Groundwater Peer Review

DATE: 9 December 2025

RE: **Mount Pleasant Operation Modification 8 – Groundwater Peer Review**

OUR REF: HA2025/19b

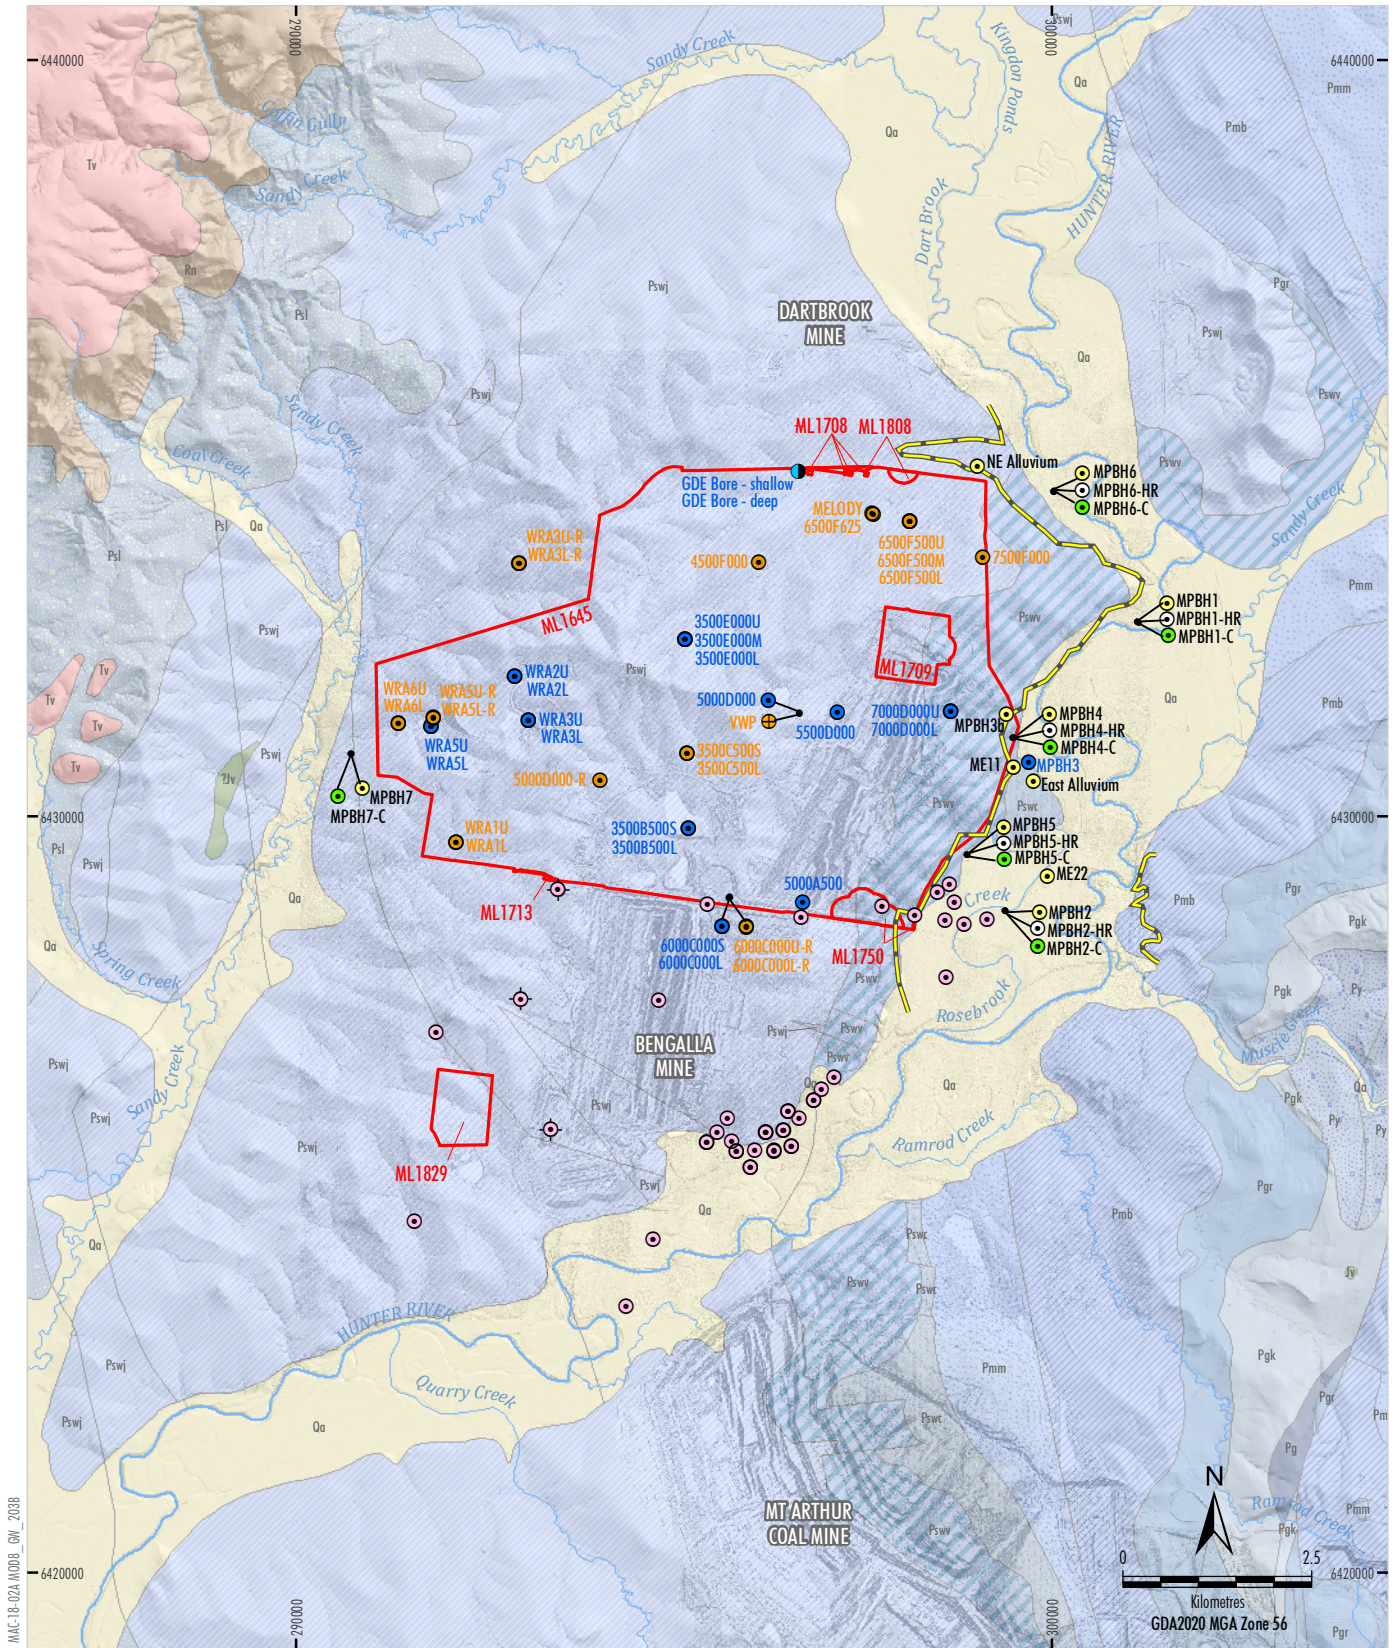
Many bores have an identification (ID) name formed from the number of metres from the western boundary; for example bore 6000C000S (and /L) was originally positioned about 6,000 m from the western boundary. I understand this bore was destroyed by open cut pit progression and had to be replaced. As shown in **Figure 1**, the replacement bore is about 2.4 km to the south-west. However, the ID has not been changed. It is strongly recommended the naming for this replacement bore is updated as adopting the same name is likely to lead to confusion and errors in interpretation, in the future, if data from these separate bores are inadvertently combined.

FIGURE No:
A 2.2

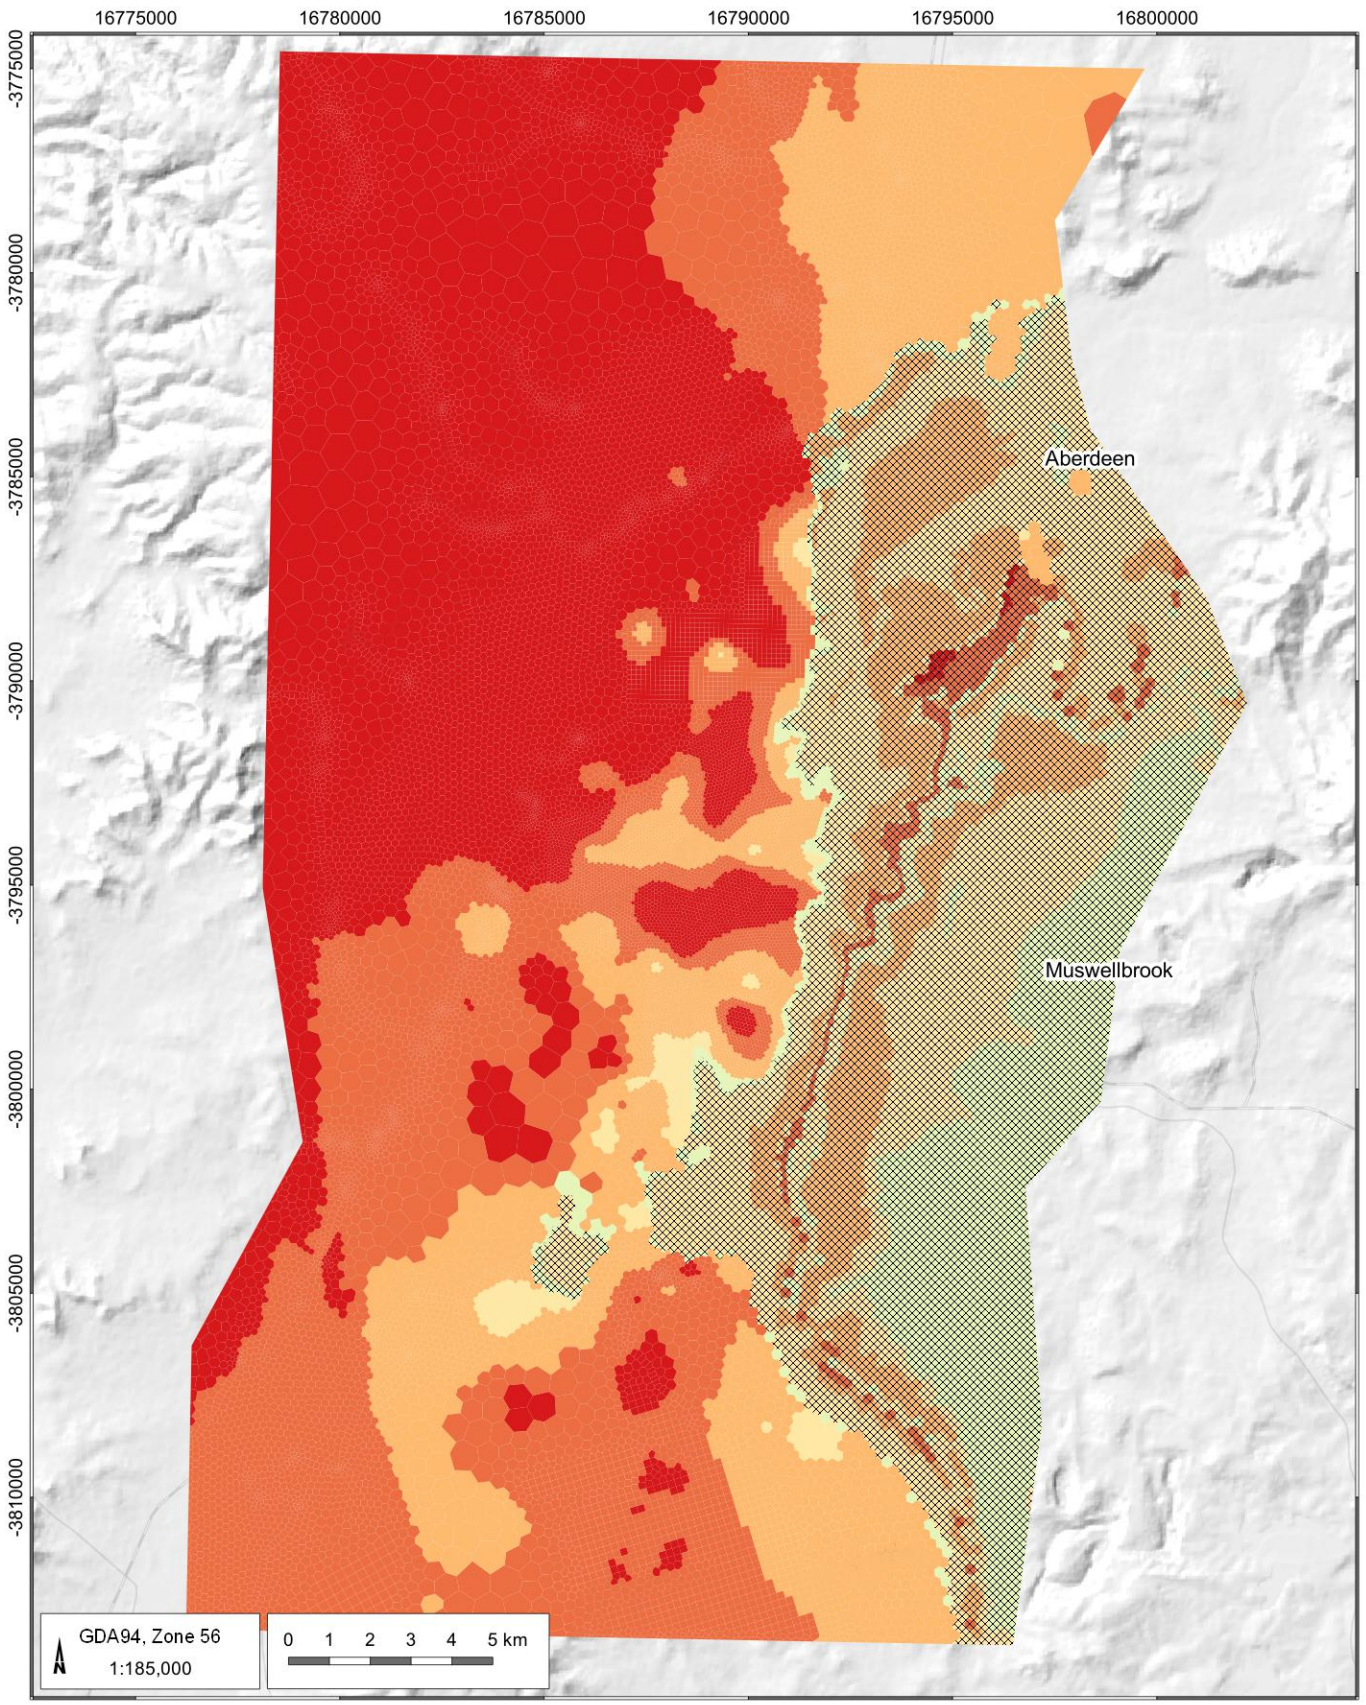
Recharge rates also have been determined by use of pilot points within three lithological zones (Figure A2.2). In addition to minimum and maximum rates, mean values are listed in Table A2.2; namely:

- Alluvium: 3.2% of annual rainfall.
- Triassic Sandstone 2.8% of annual rainfall.
- Permian 0.5% of annual rainfall.

These values are plausible and are consistent with other studies in the Upper Hunter Valley. A recharge rate of 2% has been adopted (not calibrated) for spoil; this lies within typical expected rates of 1-10%.
